Traffic Impact Study

Cloverleaf

El Paso County, CO

August 26, 2020

Figure 3: Recent Peak Hour Traffic

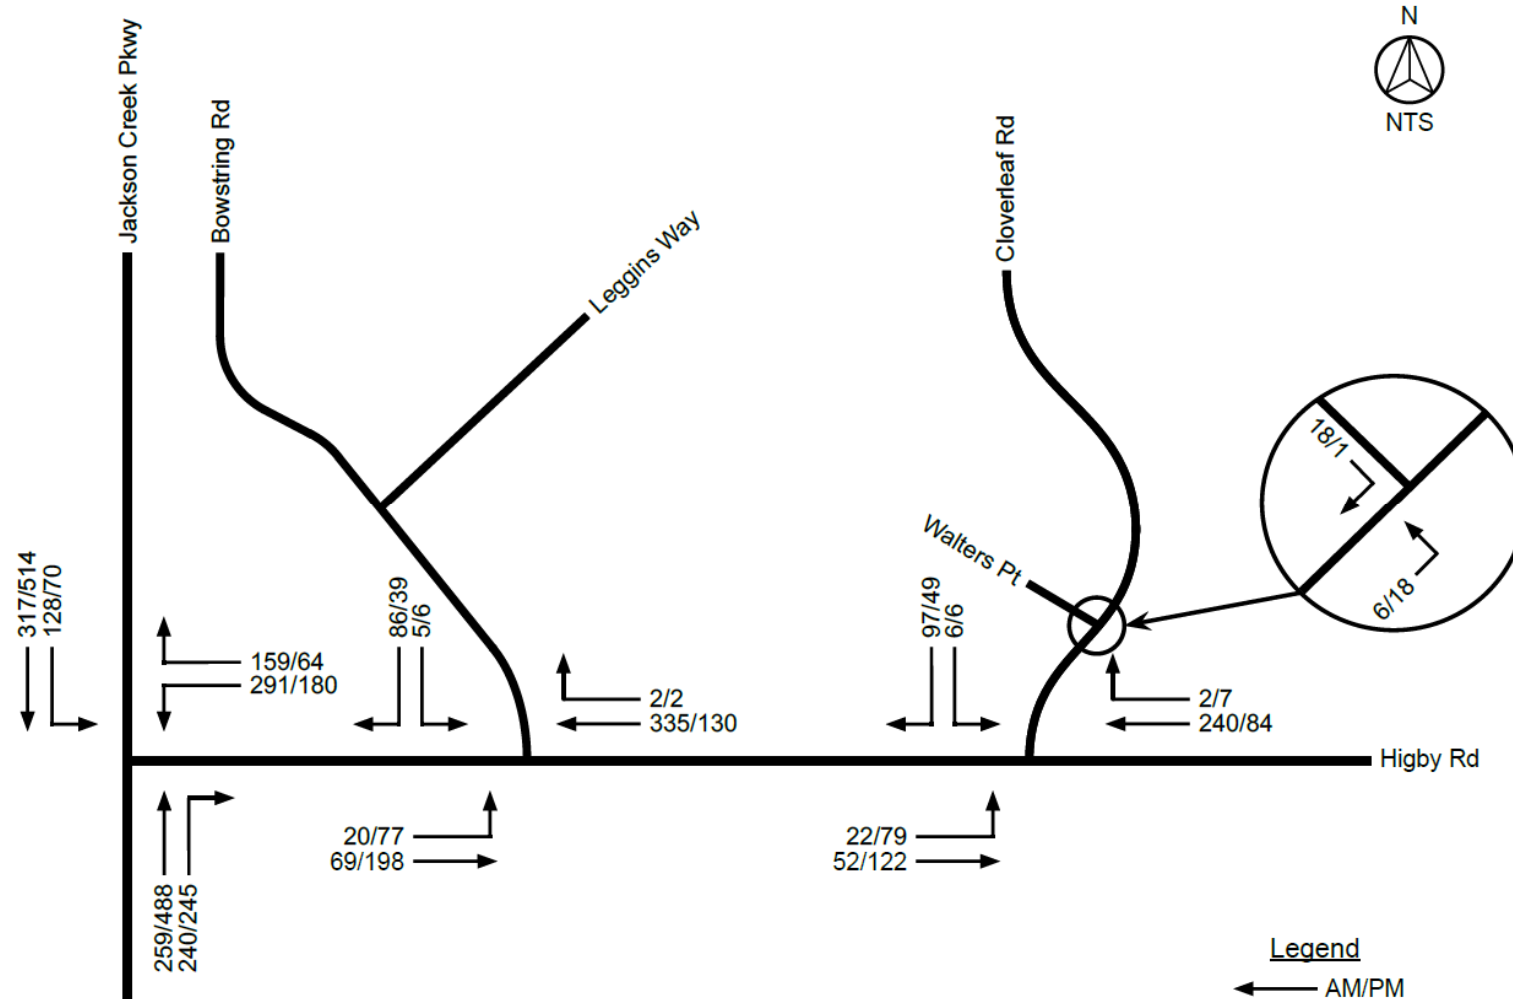
Add walter's point in the TIS analysis. The applicant submitted a deviation request classifying Walter's point as Urban Local Low Volume with approximately 450 ADT with no supporting traffic analysis for the value stated.
 Unresolved. Update Figures 3, 4, 5, 8, 9, obtain traffic count

Figure 8: 2025 Short Range Total Traffic

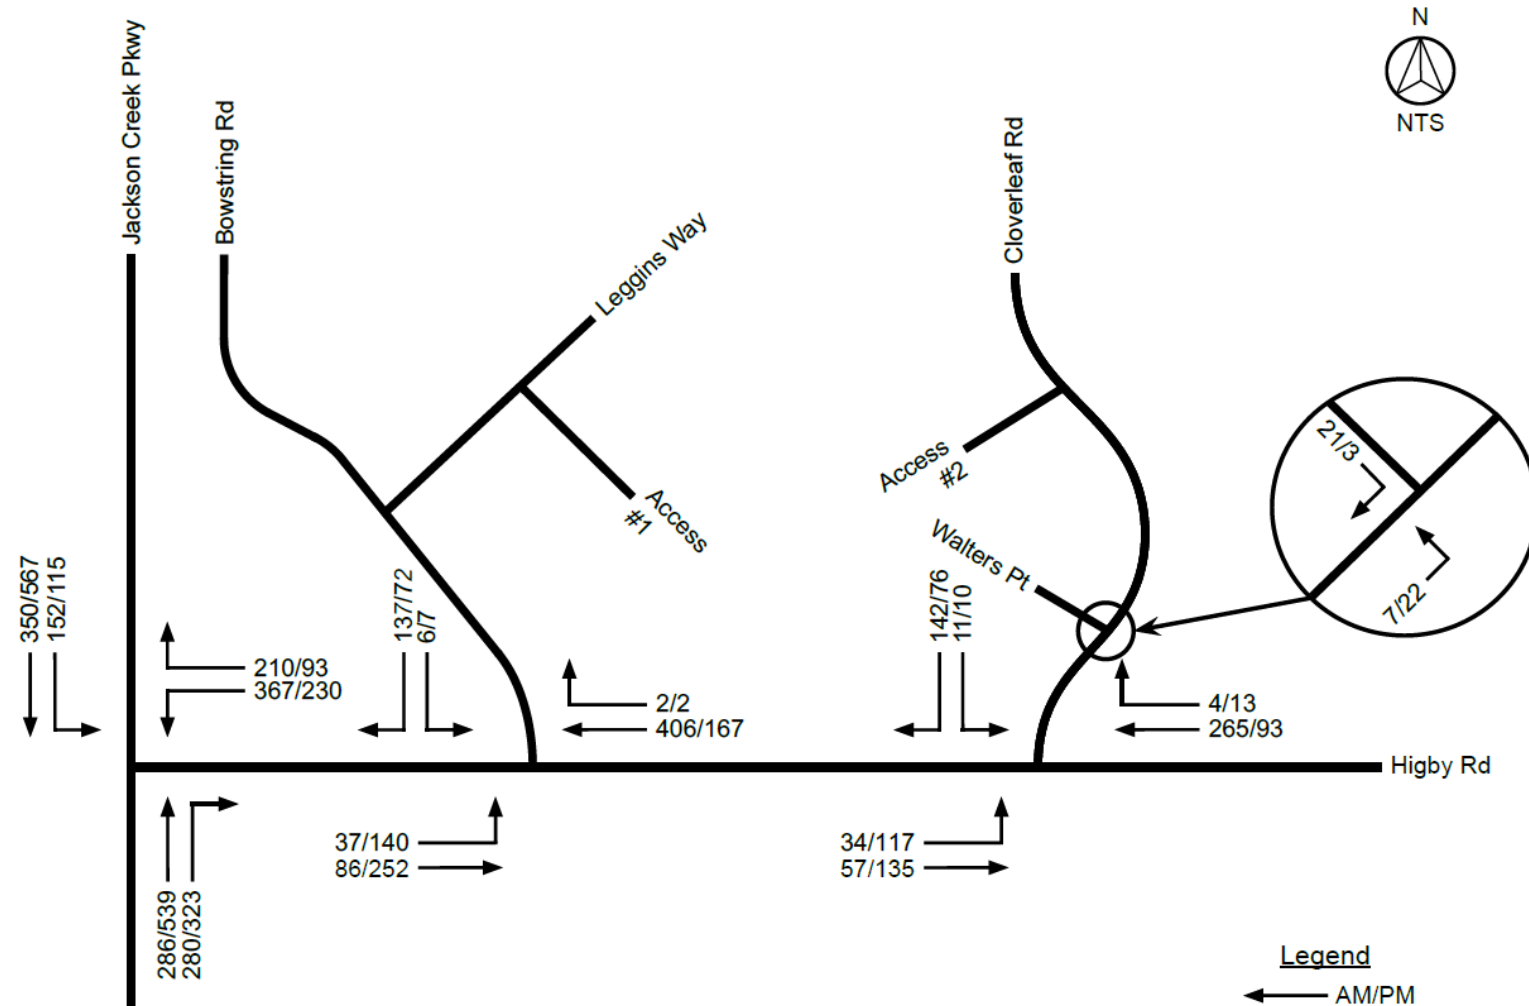
Add walters point and include the estimated ADT. Unresolved. Update Fig 8 & 9

Provide the ADT on Bowstring, Leggins & Cloverleaf in the 2025 and 2040 total traffic. Update the narrative to discuss whether or not the project results in the existing roads exceeding the design capacity (ECM Table 2-5) for rural local roads. Provide mitigation improvement recommendations. Unresolved.

## School Pedestrian Routing to Lewis Palmer High School (0.2 miles)

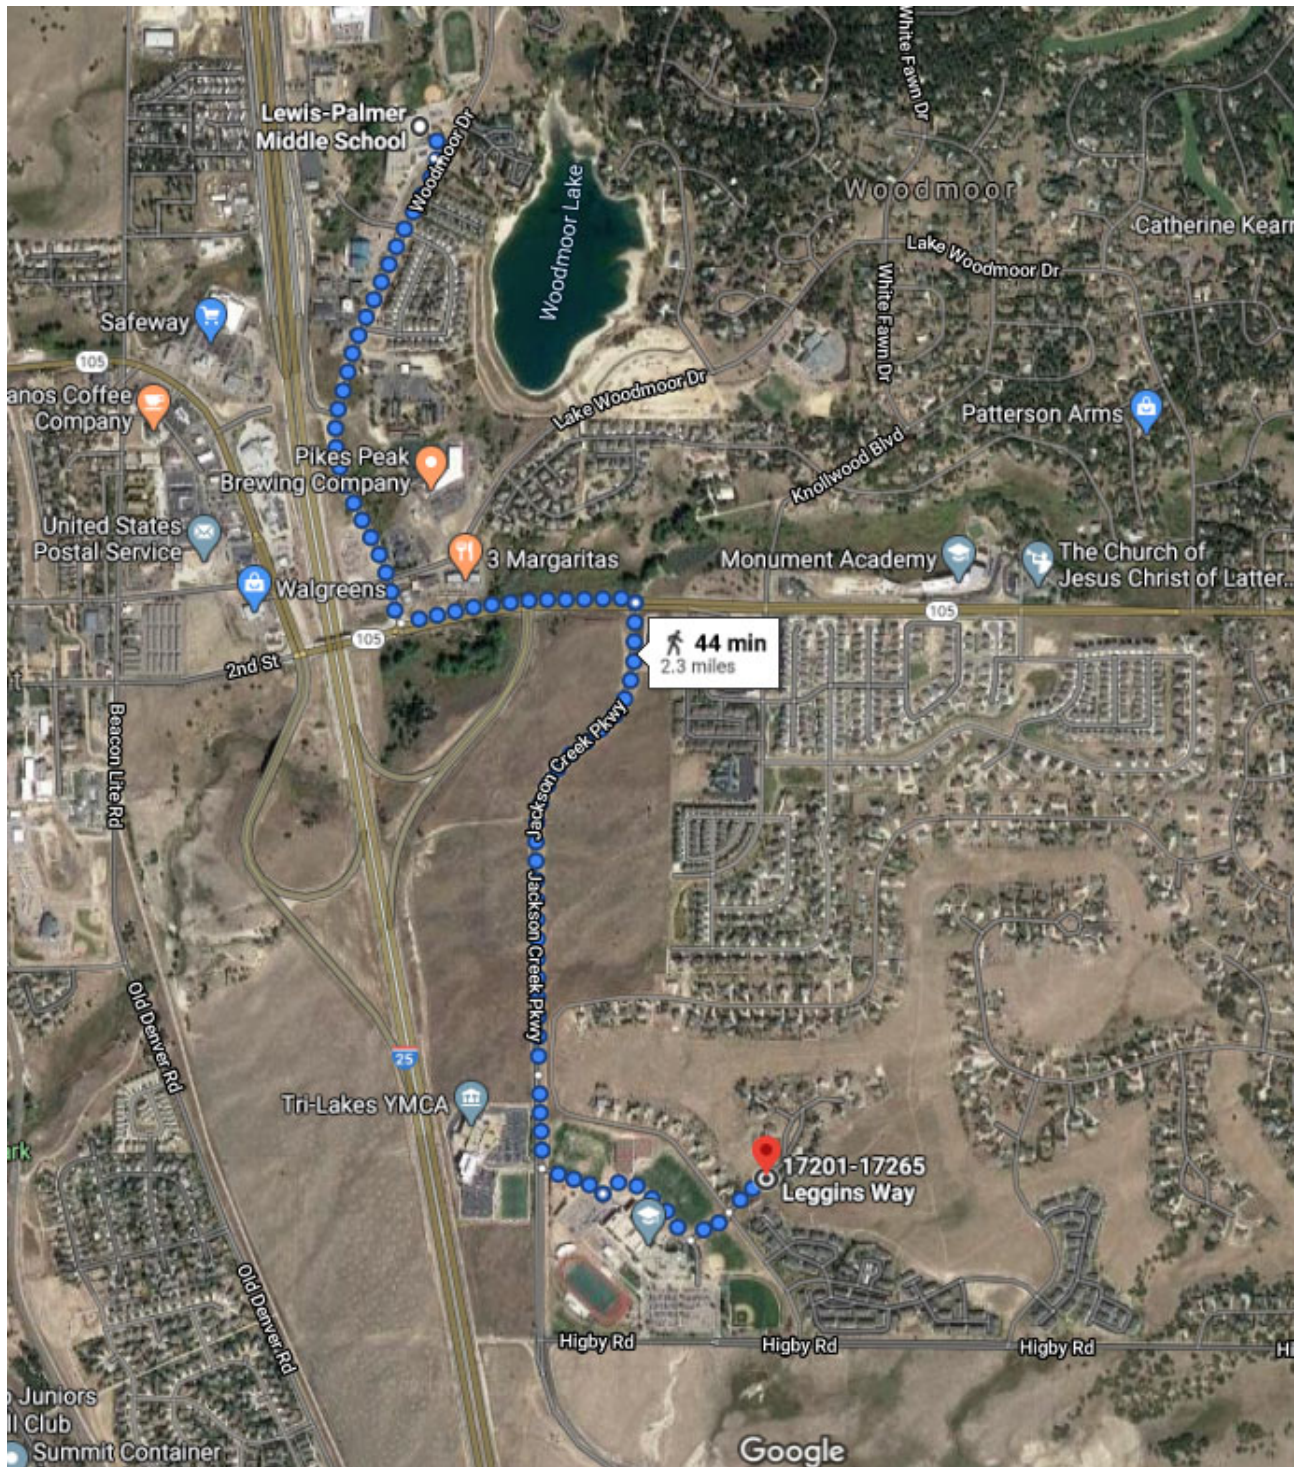
There is no pedestrian path on Leggins Way or crossing at the intersection of Leggins Way/Bowstring Rd and Leggins Way does not appear to have adequate shoulder to be used by pedestrian. Staff does not see how the existing improvements support the conclusion that adequate pedestrian routing to Lewis Palmer HS exist between this development and the school. Include proposed recommendation for improvements that need to be done to provide adequate pedestrian routing.

Appendix E: Sight Distance

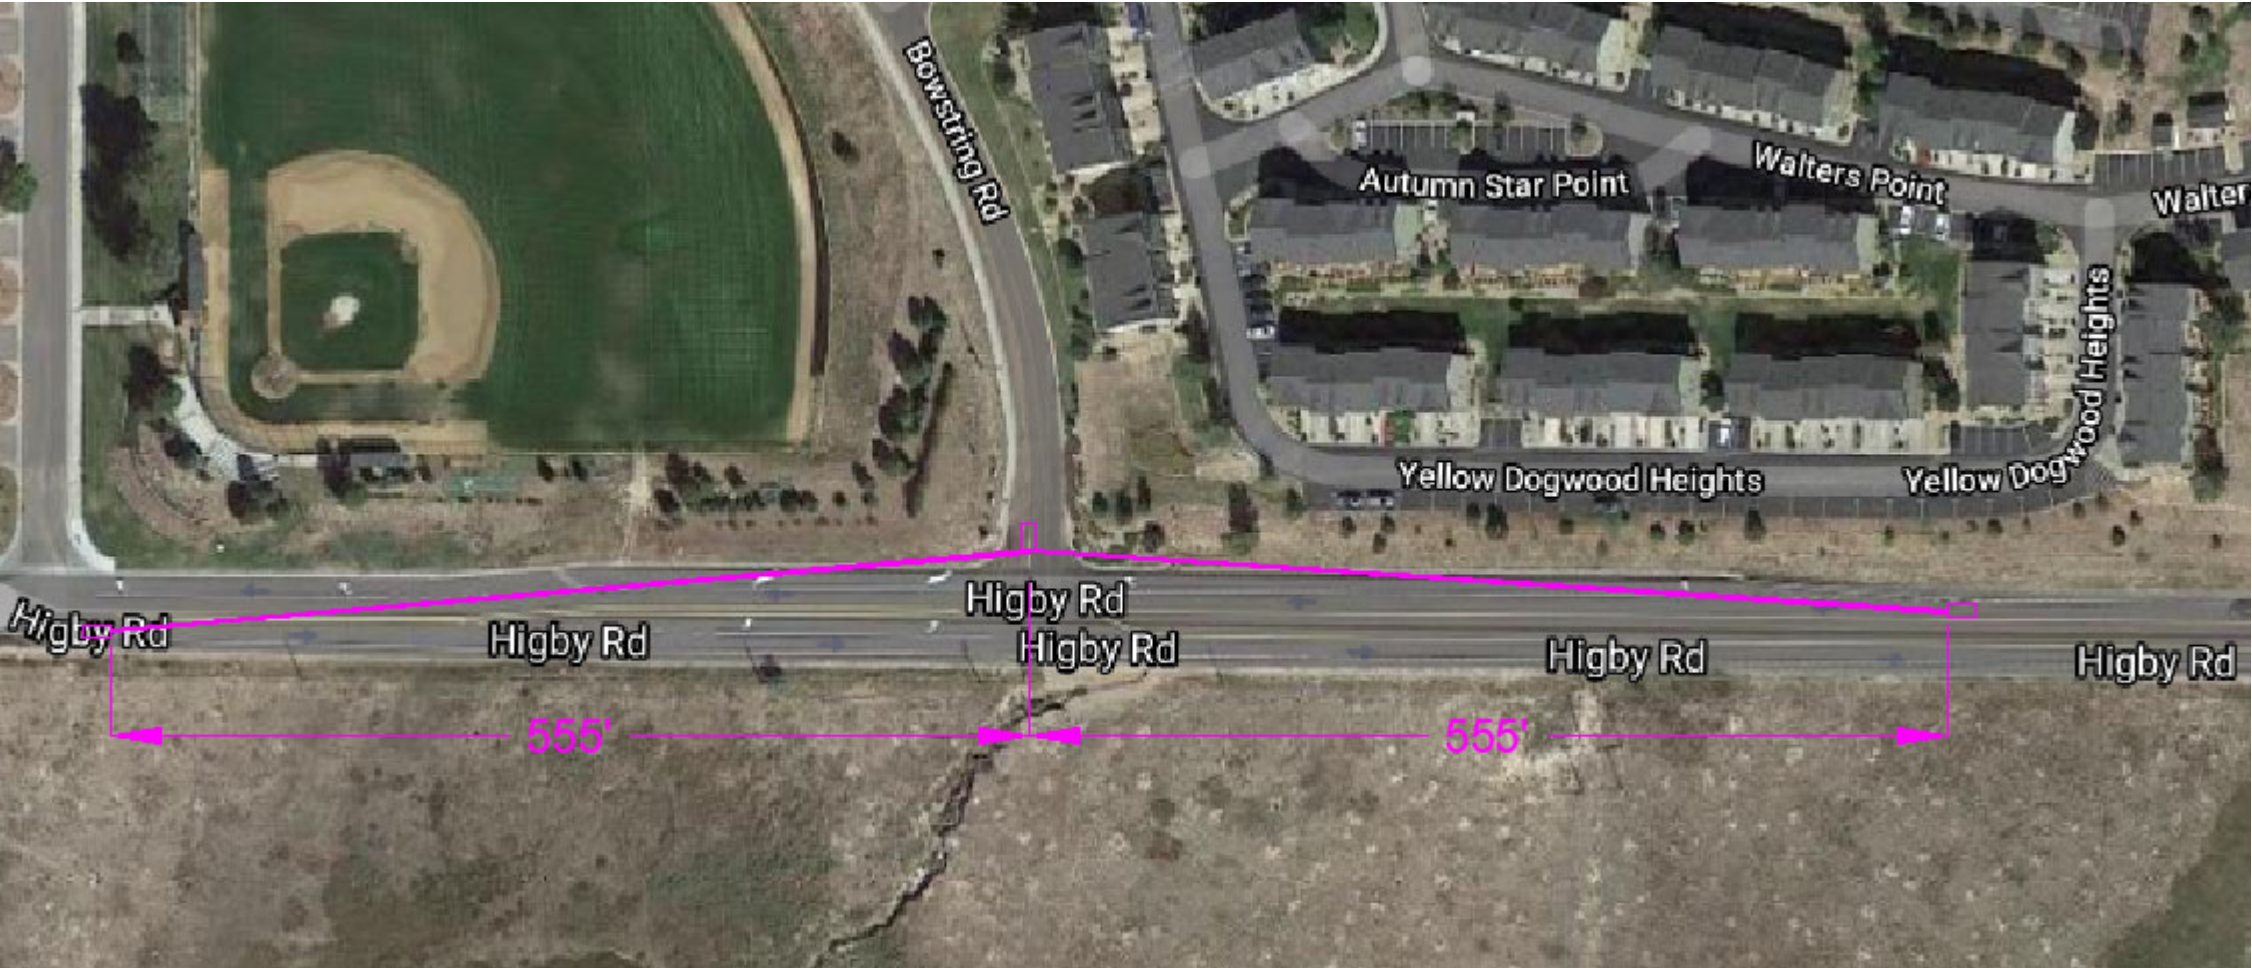
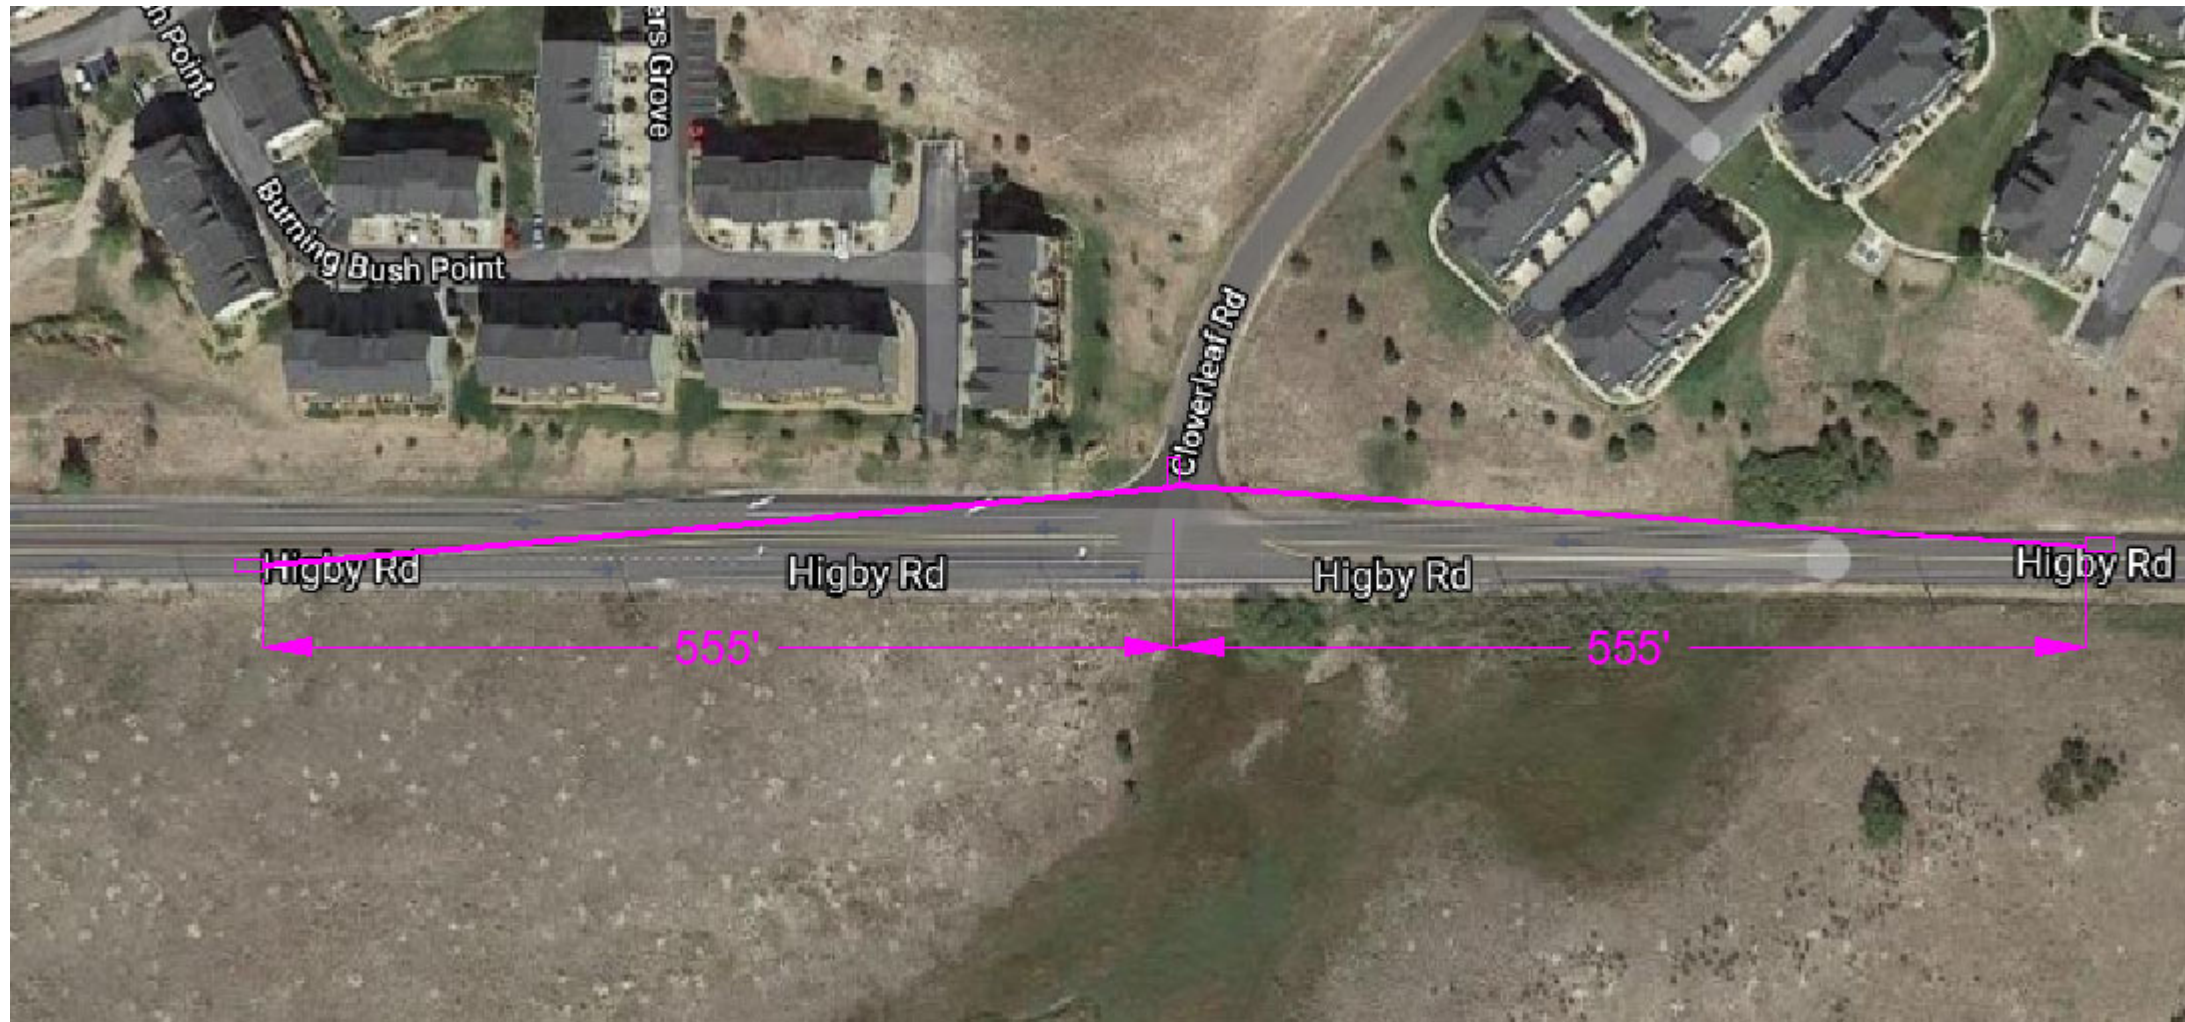
Add a section for sight distance analysis/recommendation at the proposed access locations. Include an exhibit showing the sight distance.

- Include analysis/exhibit & conclusion/recommendations for Leggins Way/White Clover Dr. The line of sight appears to encroach into the adjacent lot to the west which is not a part of this development. A deviation request may be required to identify proposed alternative if the proposed mitigation does not meet criteria.

- Include analysis/exhibit & conclusion/recommendations for Walters Point/Cloverleaf Road intersection. The line of sight appears to encroach into the lots to the north.

- Include analysis/exhibit & recommendations for Crimson Clover Dr & Clover Leaf Road. With Blue Mist Grove at the top of the hill the intersection sight distance looking south does not appear to meet the required SSD.

- Include analysis/exhibit & conclusion/recommendations for the southern lots along Walters Point regarding driveway access sight distance. In the vicinity of lot 145 is the top of the hill with the following posted sign "Hill Blocks View". See the deviation request for private road for the original roadway P&P for Walters Point. Driveway access sight distance criteria is in ECM Chapter 2 Section 2.4
